Your ref: 3/2018/0837
Our ref: DC/18/4250
Date: 17-OCT-18

Location: Former Household Waste Recycling Centre off Whalley Road Langho BB6 8AB
Proposal: Development of the former waste recycling centre to create four class B1/B8 business units

With regard to the above development proposal, United Utilities Water Limited ('United Utilities') wishes to provide the following comments.

Drawing Title  
**Proposed Site Plan and Longsight Road**

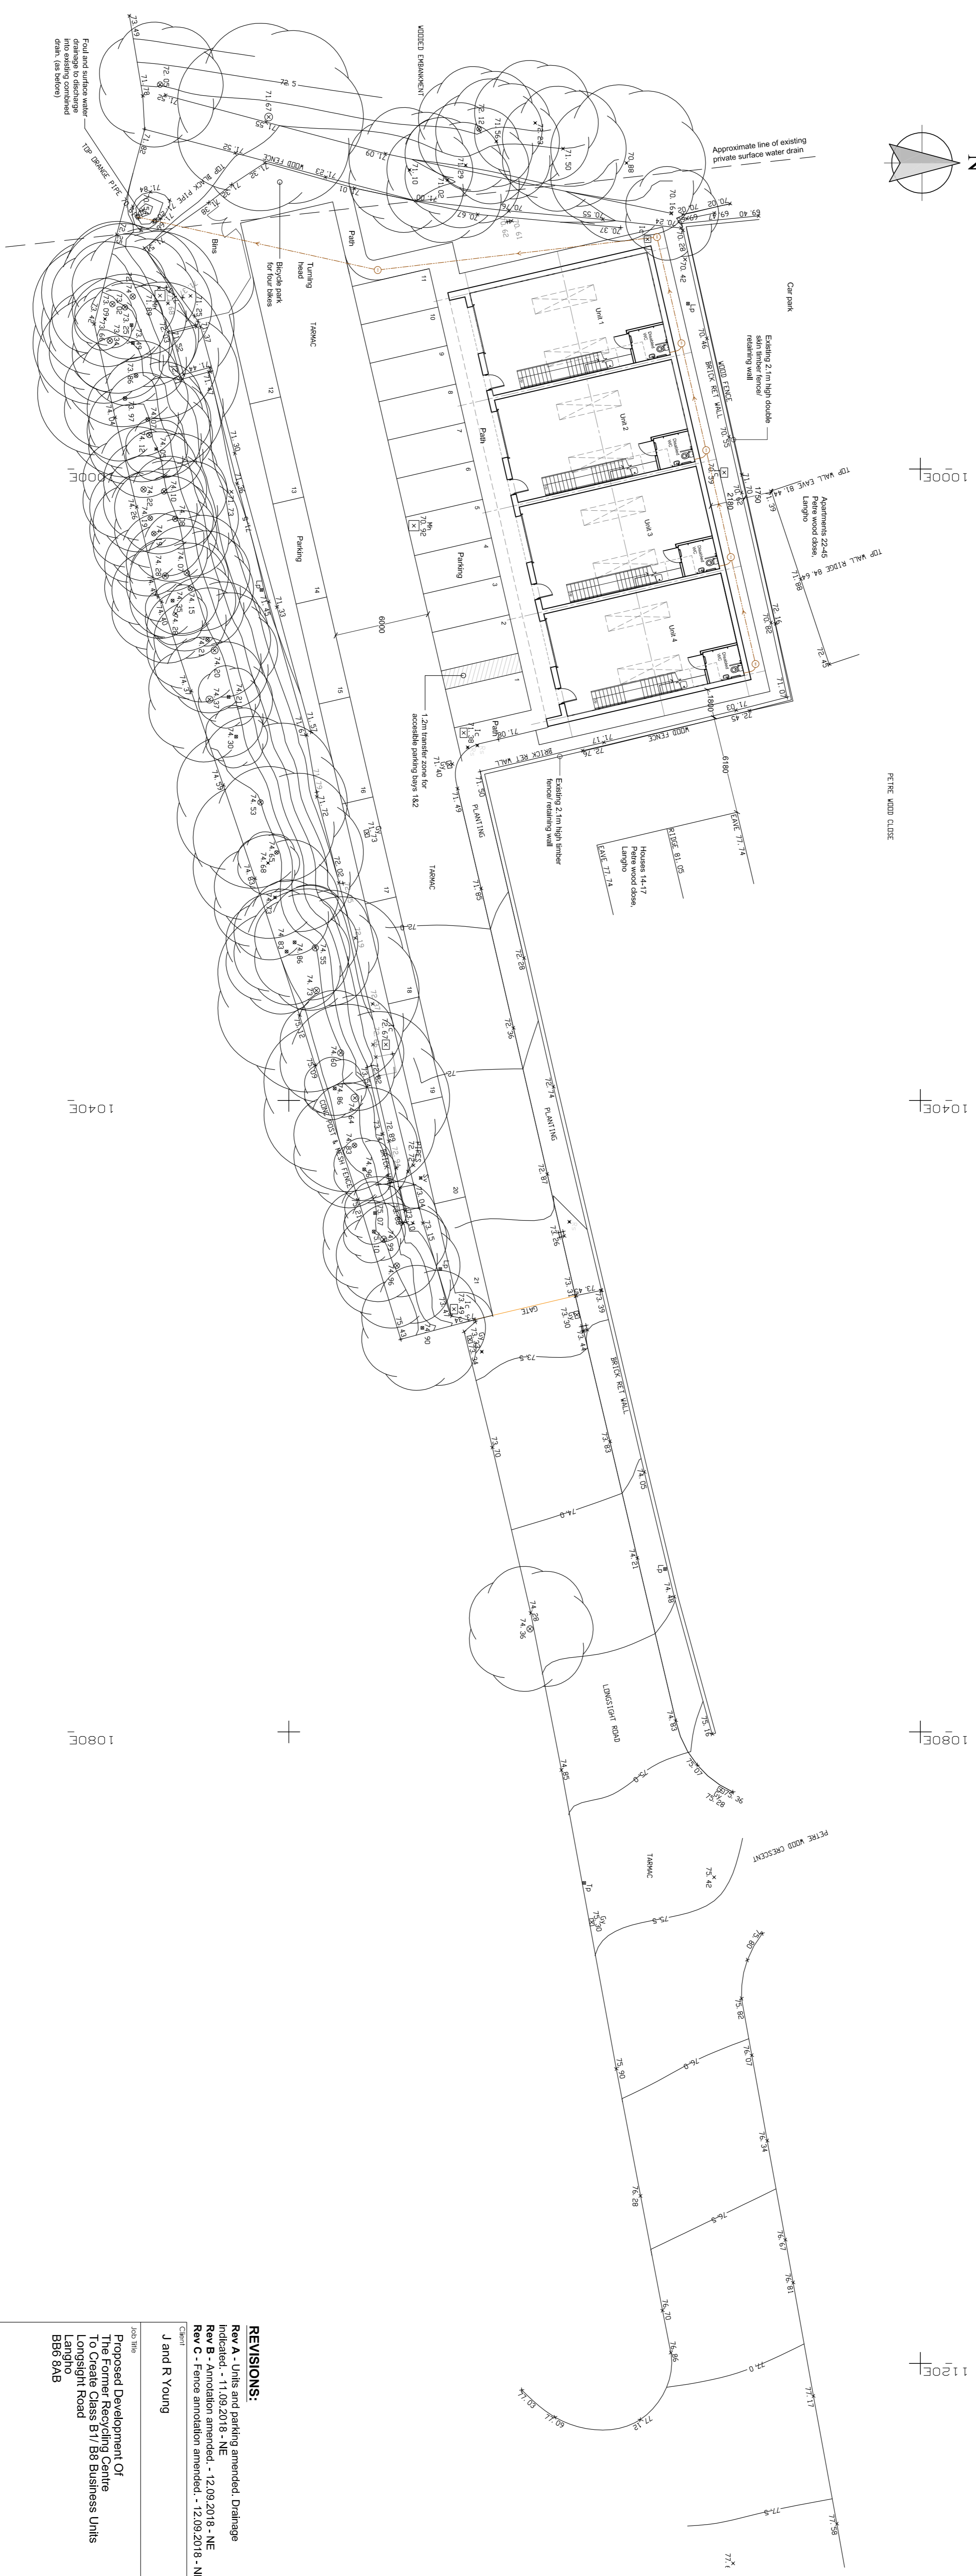
We note the applicant has indicated on their application form that surface water will be disposed of via 'Mains Sewer'. **Our current position is that we must OBJECT to this drainage proposal** on the basis that a culverted watercourse, in the applicant's ownership (as the riparian owner) crosses the proposed development site. The applicant has provided no evidence of investigating the drainage hierarchy prior to proposal to connect to the public sewer.

Foul and surface water shall be drained on separate systems.

Prior to the commencement of any development, a surface water drainage scheme, based on the hierarchy of drainage options in the National Planning Practice Guidance with evidence of an assessment of the site conditions shall be submitted to and approved in writing by the Local Planning Authority.

The surface water drainage scheme must be in accordance with the Non-Statutory Technical Standards for Sustainable Drainage Systems (March 2015) or any subsequent replacement national standards and unless otherwise agreed in writing by the Local Planning Authority, no surface water shall discharge to the public sewerage system either directly or indirectly.
